Appeal Decision

Appeal Ref: APP/T2350/W/24/3354200

27 & 29 Bawdlands, Clitheroe, Lancashire BB7 2LA

- The appeal is made under section 78 of the Town and Country Planning Act 1990 (as amended) against a refusal to grant planning permission.
 - The appeal is made by Mr Mark Byrne of Boutique Homes Ltd against the decision of Ribble Valley Borough Council.
 - The application Ref is 3/2024/0552.
 - The development proposed is 'Change of use from Class E/Class C3 to house in multiple occupation with 8no rooms Sui Generis Class'.
-

Client: Boutique Homes Ltd		
Project: Proposed Alterations 27-29 Bawdlands Clitheroe		
Dwg title: Proposed Side Elevation		
Scale @ A3: 1:50	Date: 05.06.24	Drawn by: PD
Drawing no: 1569 - 1 - 11		Rev: B

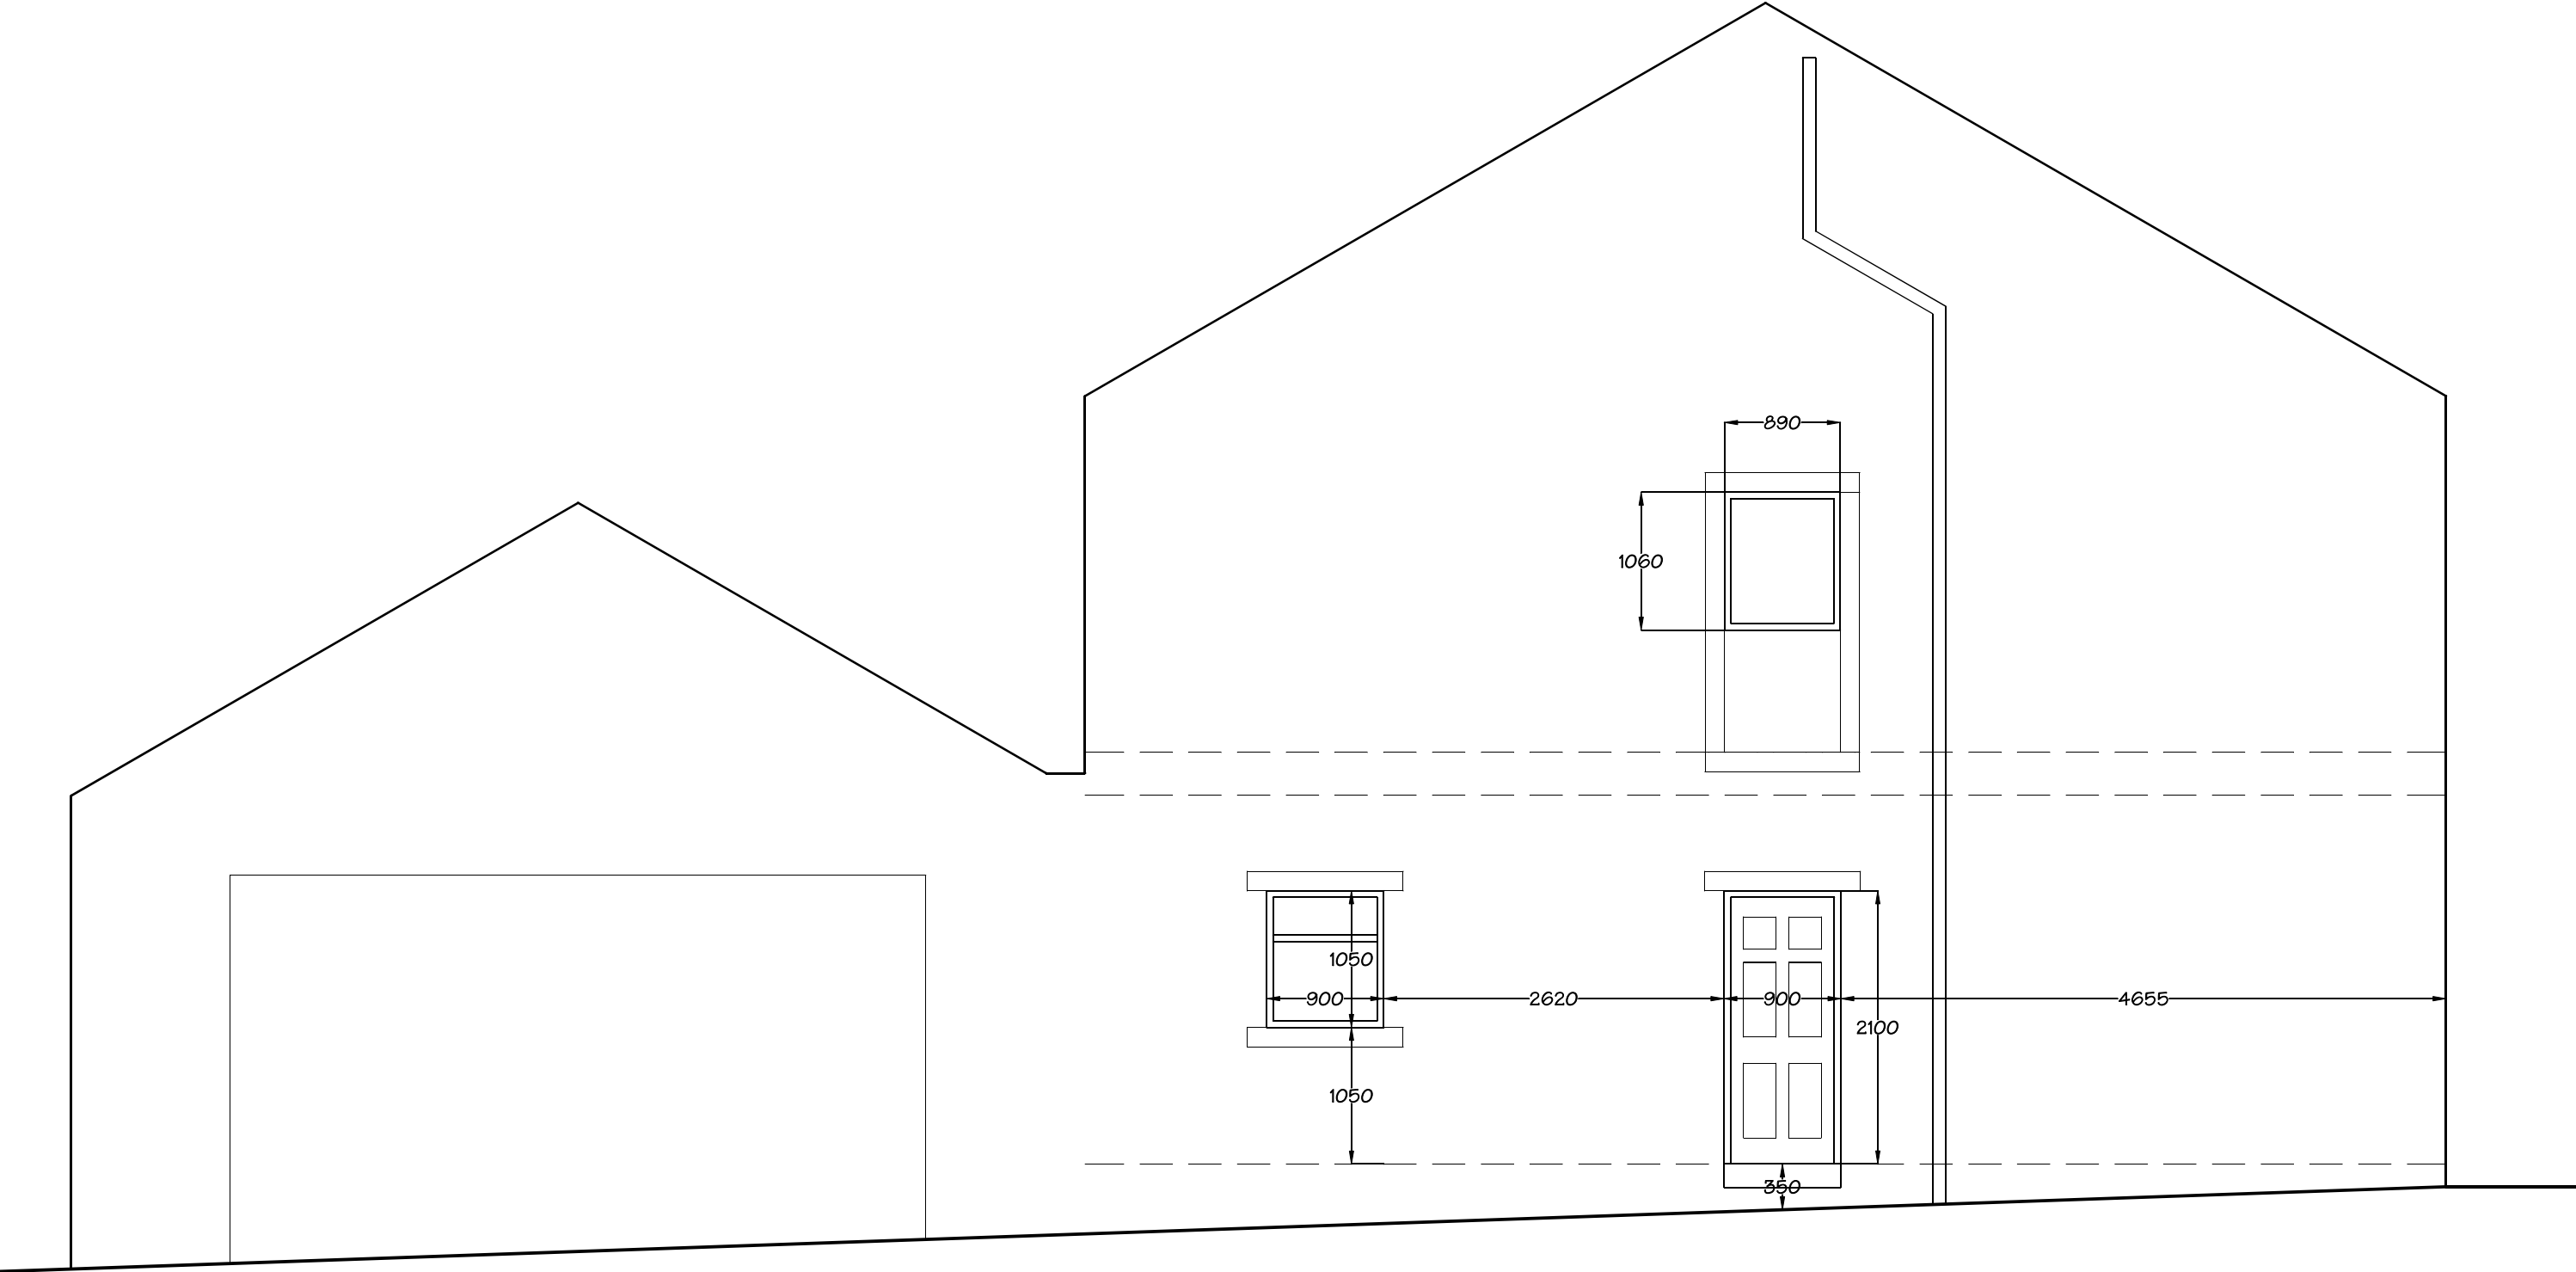
14. However, at the time of my site visit, this area was occupied by washing machines and while an external door had been created to Corporation Street, this doorway included three steps down to the pavement. The proposed plans suggest a ramped access, but no section drawing has been provided for this area, showing how the difference in levels would be accommodated, what the resulting gradient would be, and whether the internally opening door could be accommodated with a ramp. As such, I am not satisfied from the information before me, that this internal refuse storage area would be useable by future occupiers, particularly when having to move heavy refuse bins outside for collection. As no alternative refuse
